Proposed Addendum 06 – POST BIDDate: April 16, 2004

Regarding: **Logan Place SRO Apartment – Bidding Documents**Subject: **Proposed Addendum 06**

The following addendum items apply to the project known as the **Logan Place** located in Portland, Maine.

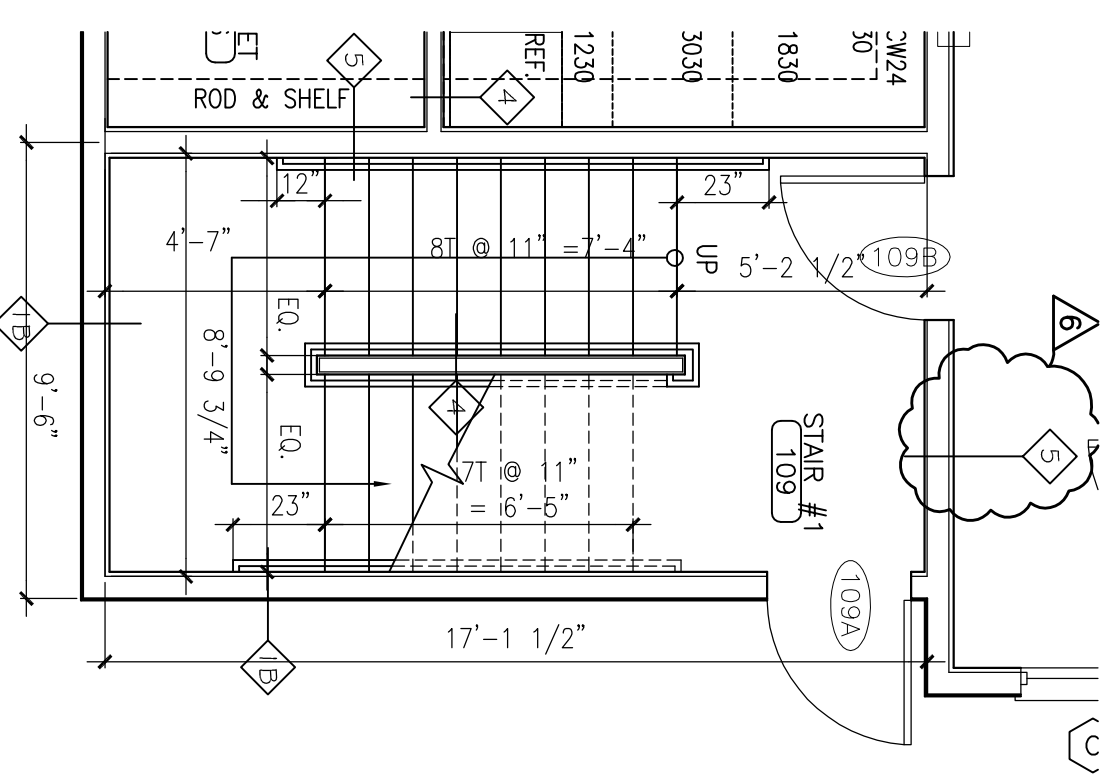
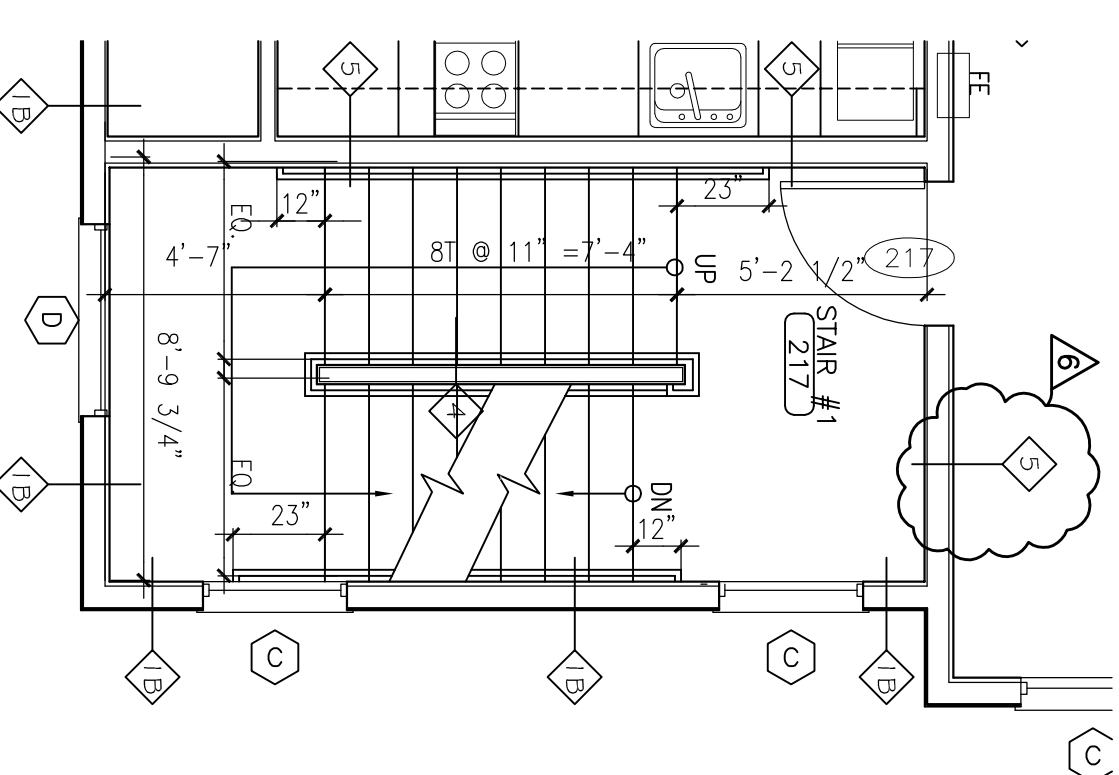
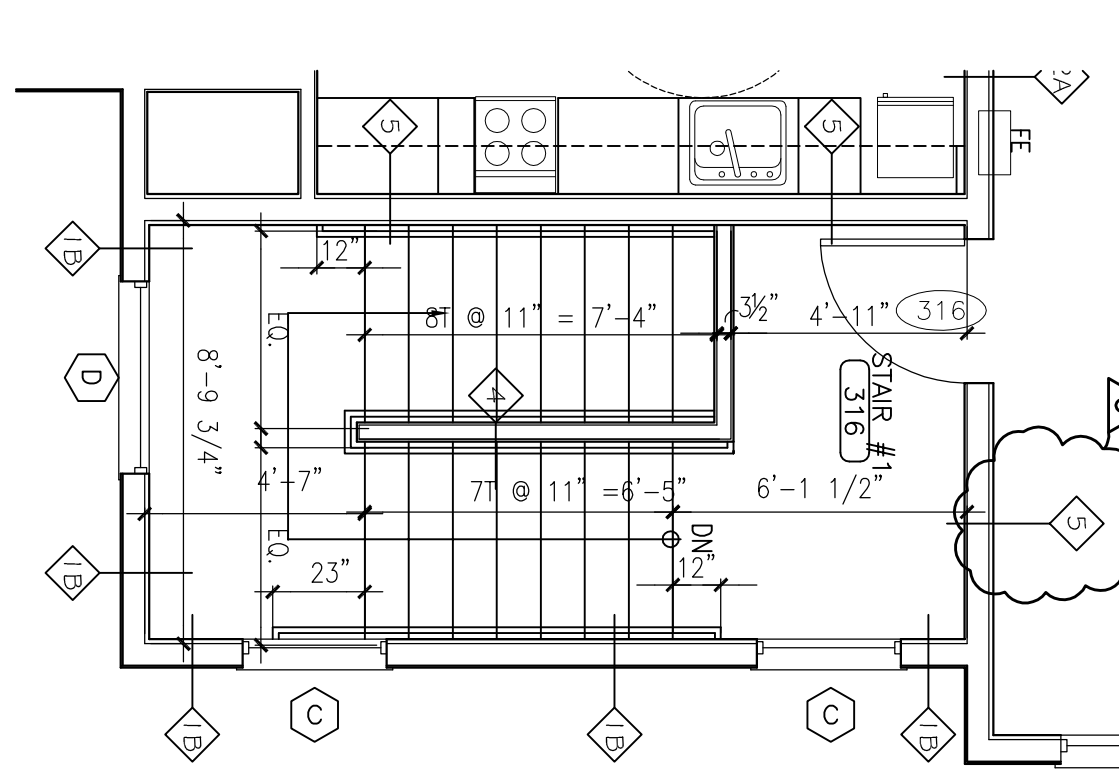
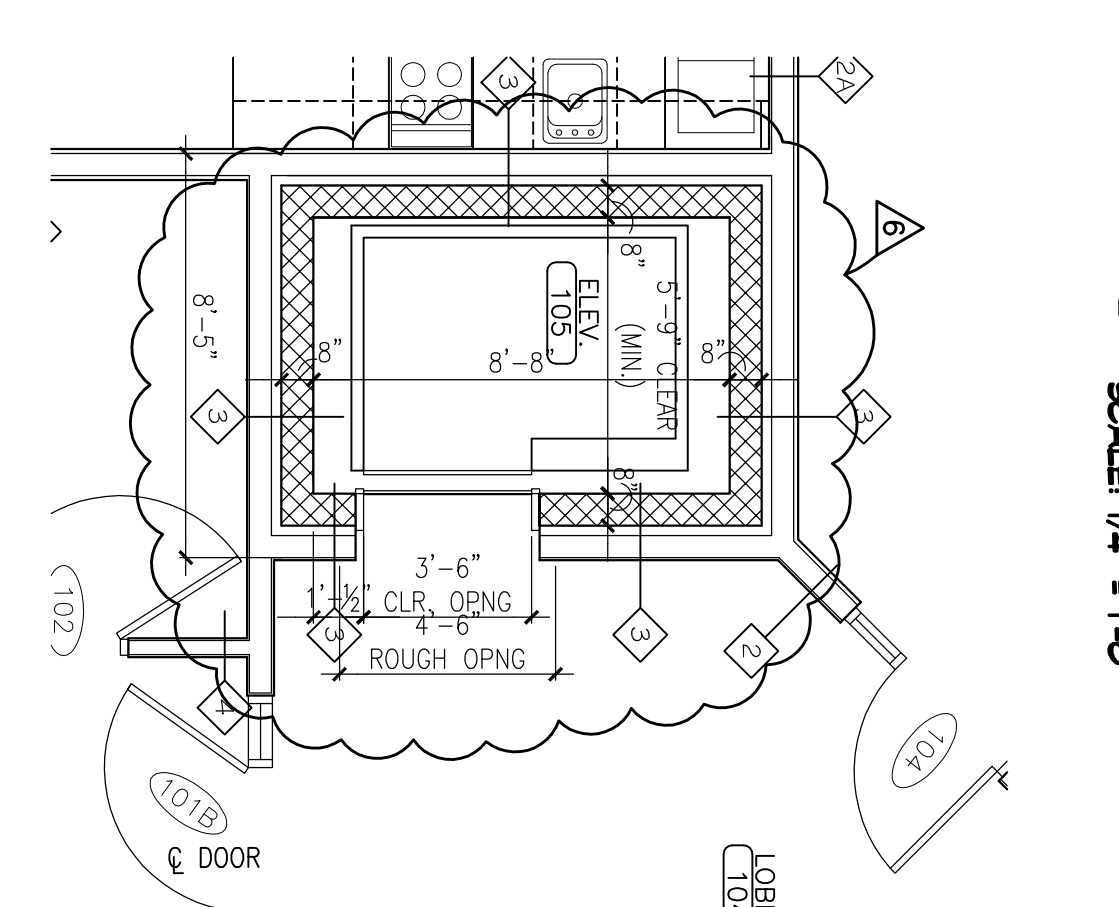
3. See revised drawing A1.5 for revised Wall Type on Stairs – indicated with revision cloud.
4. Change elevator shaft dimension from 8’-4”x5’-9” to 8’-8”x5’-9” - See drawing A1.7/7 for details.

C STAIR DETAIL
SCALE: 3/8" = 1'-0"

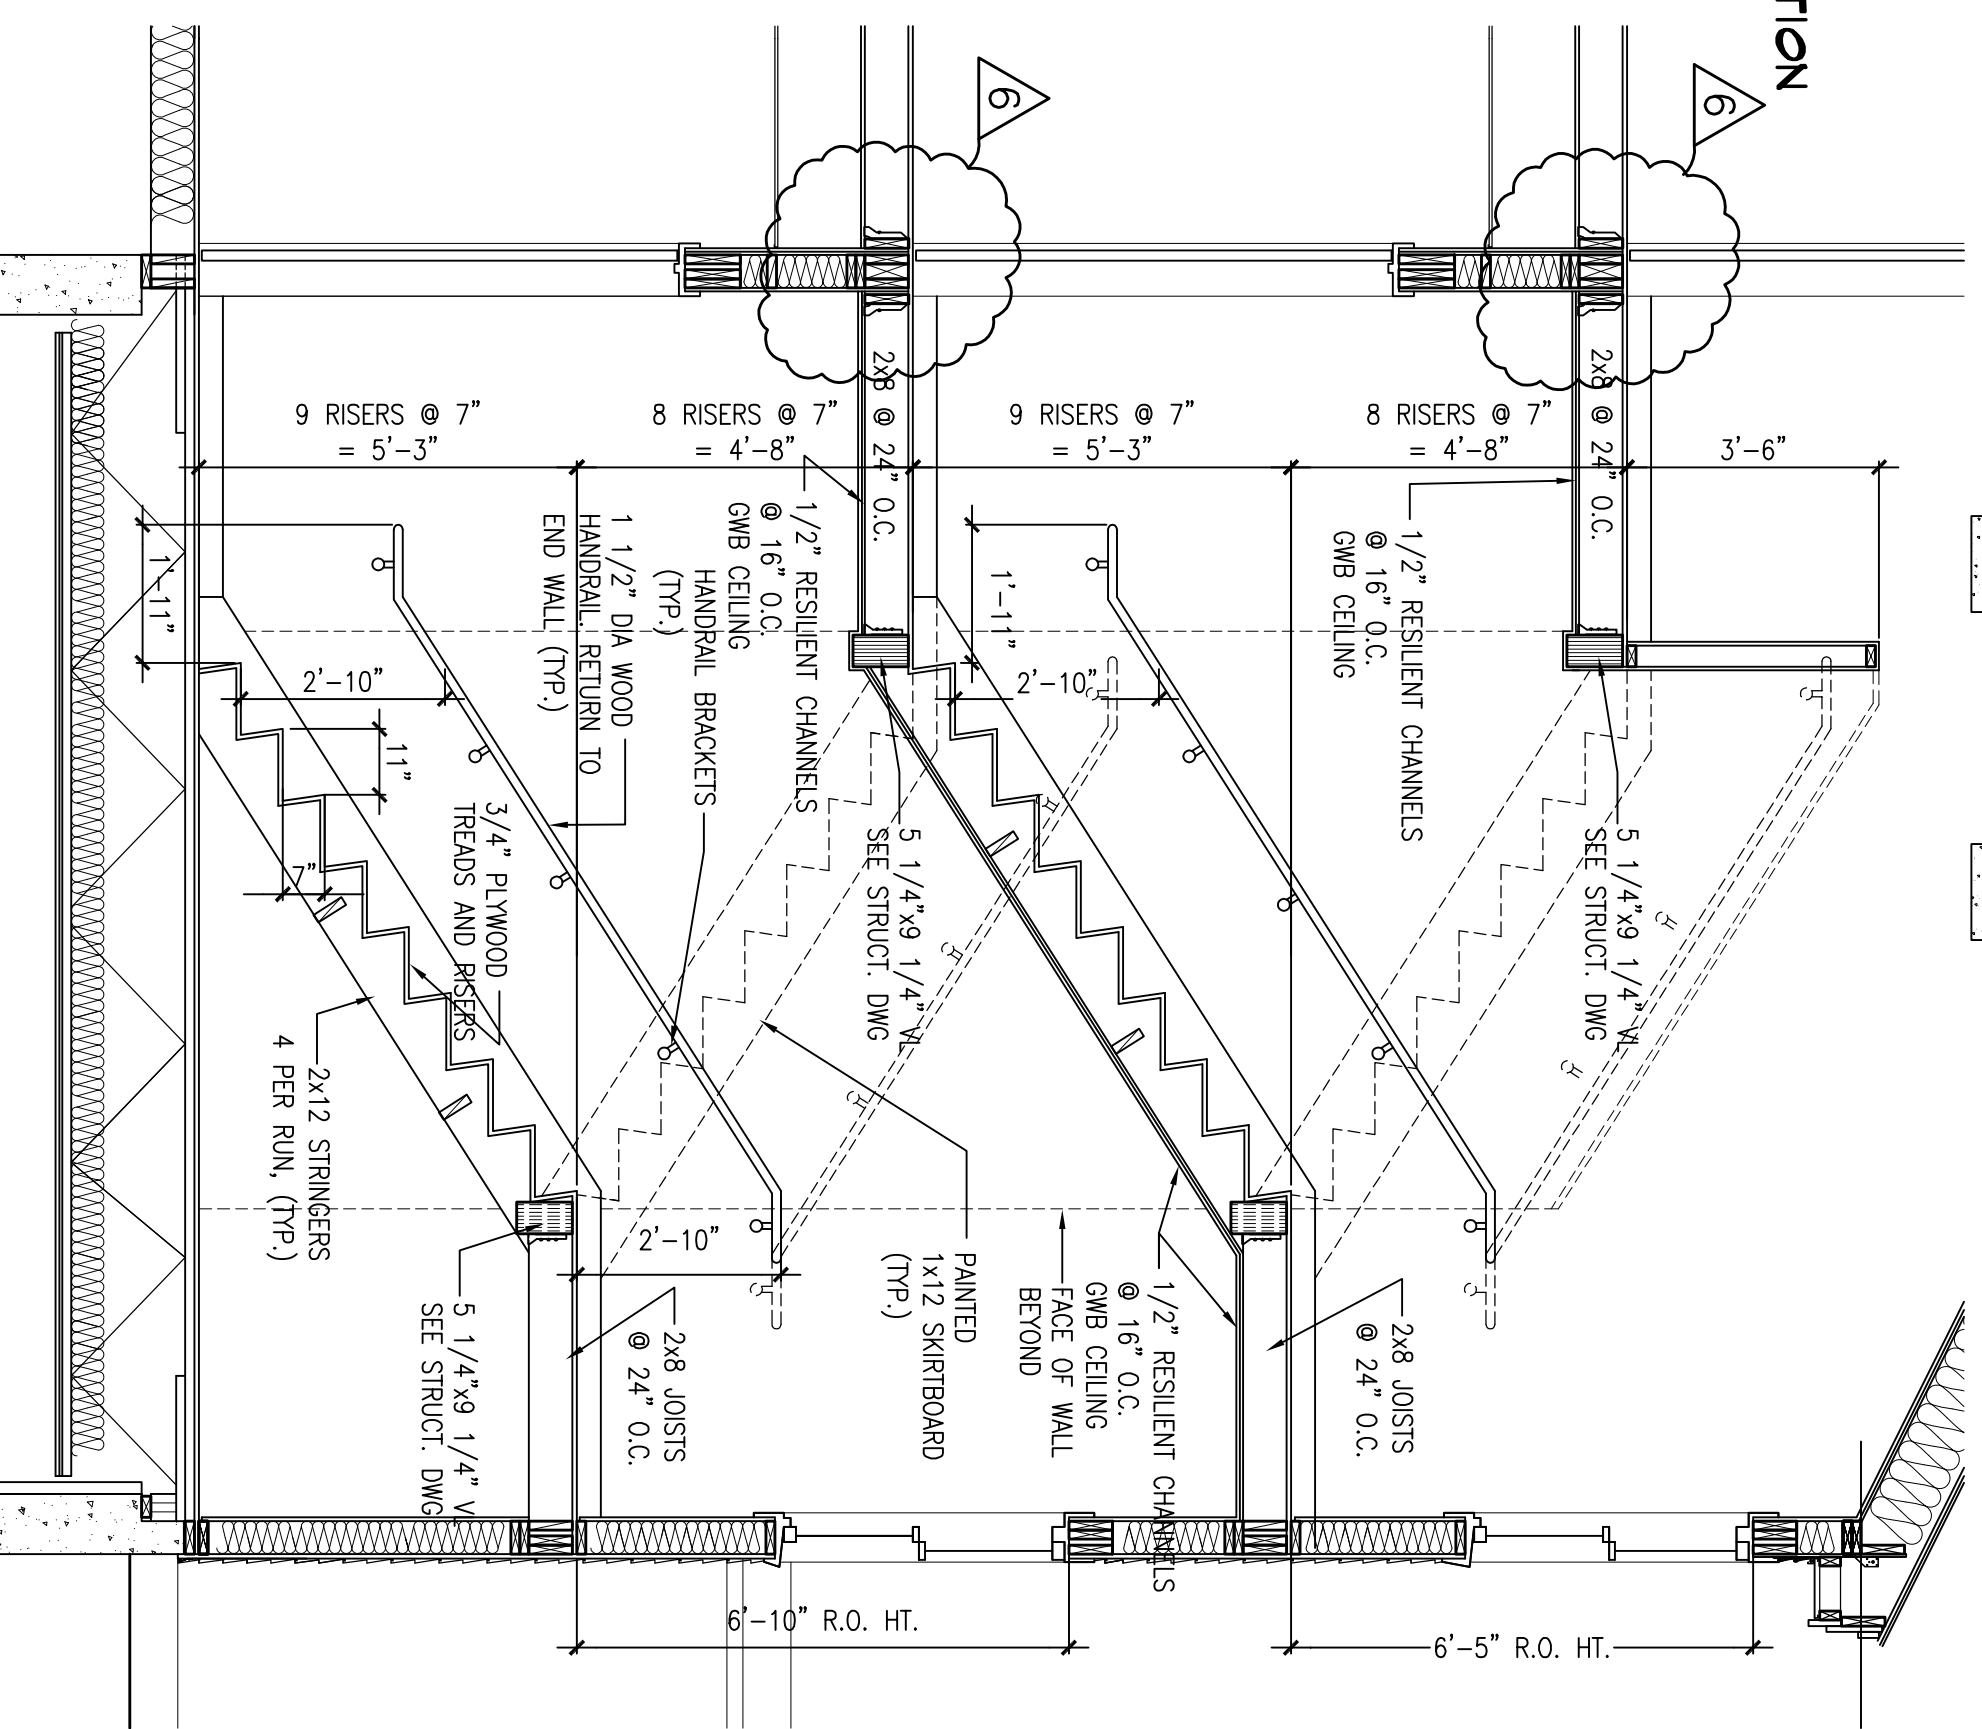
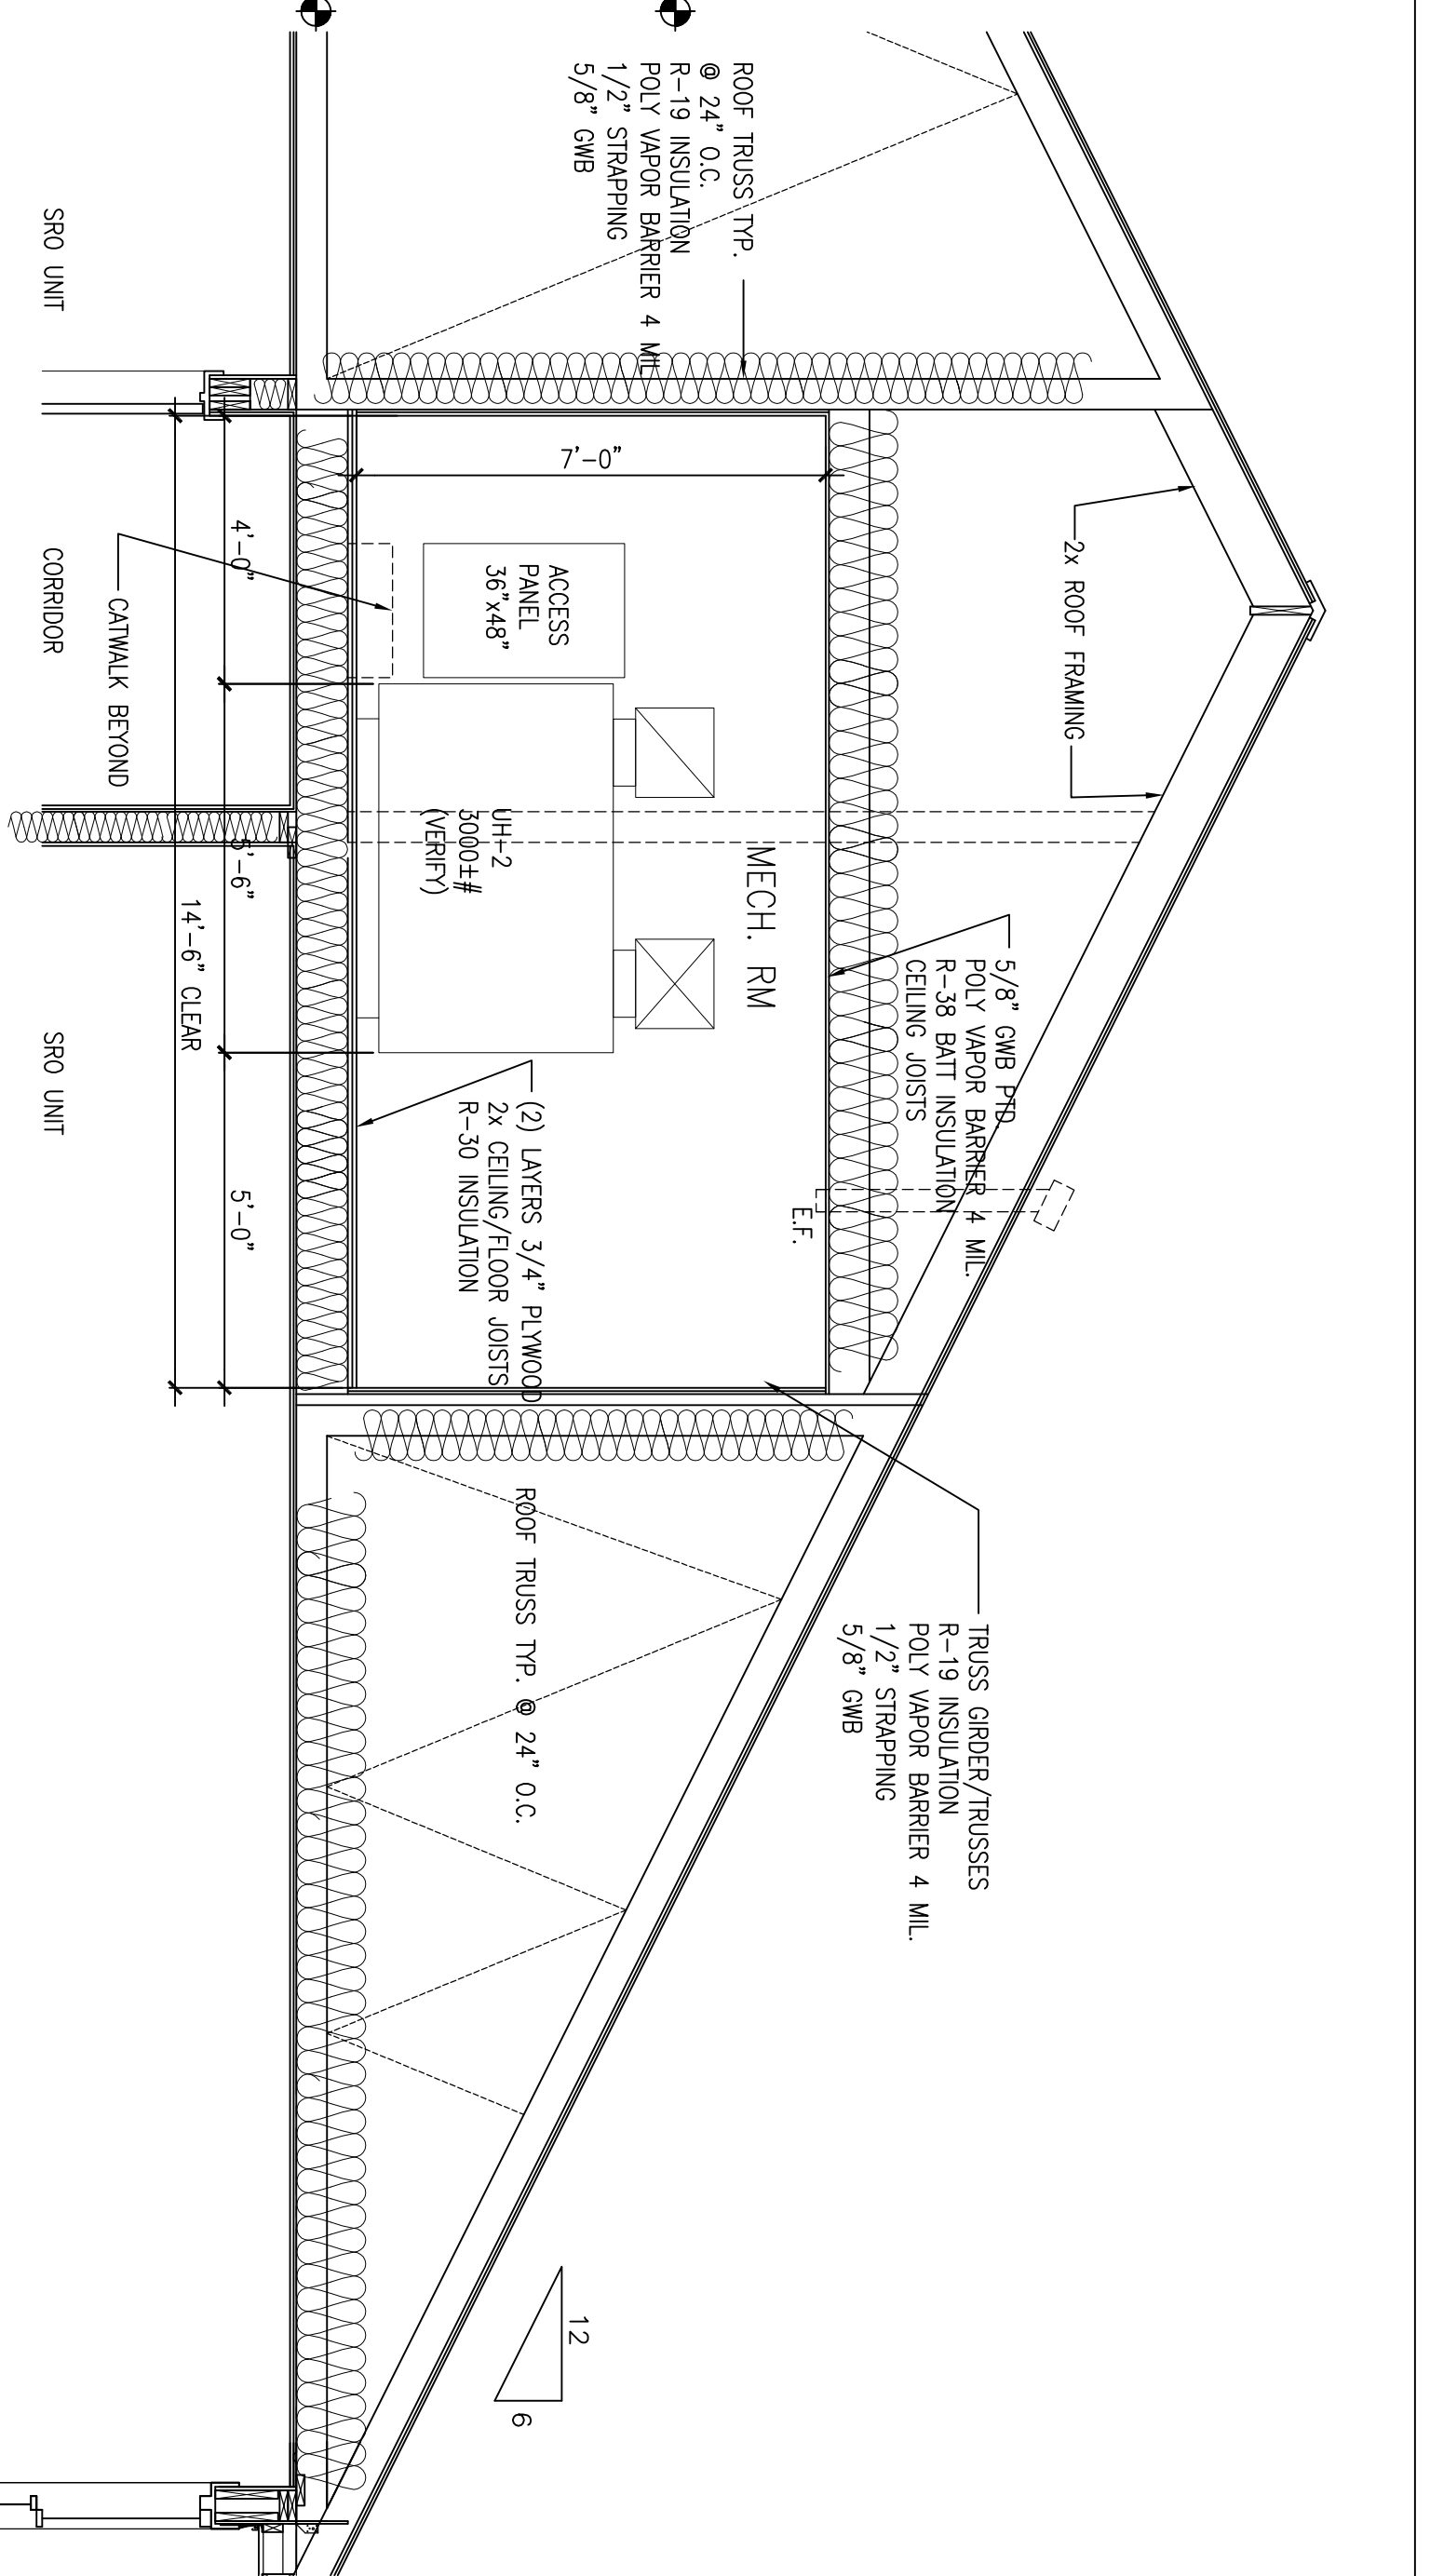
6. See revised drawing A5.1 for revised Stair Section C – indicated with revision cloud.
7. See revised drawing A7.1 for added new detail 14 – indicated with revision cloud.
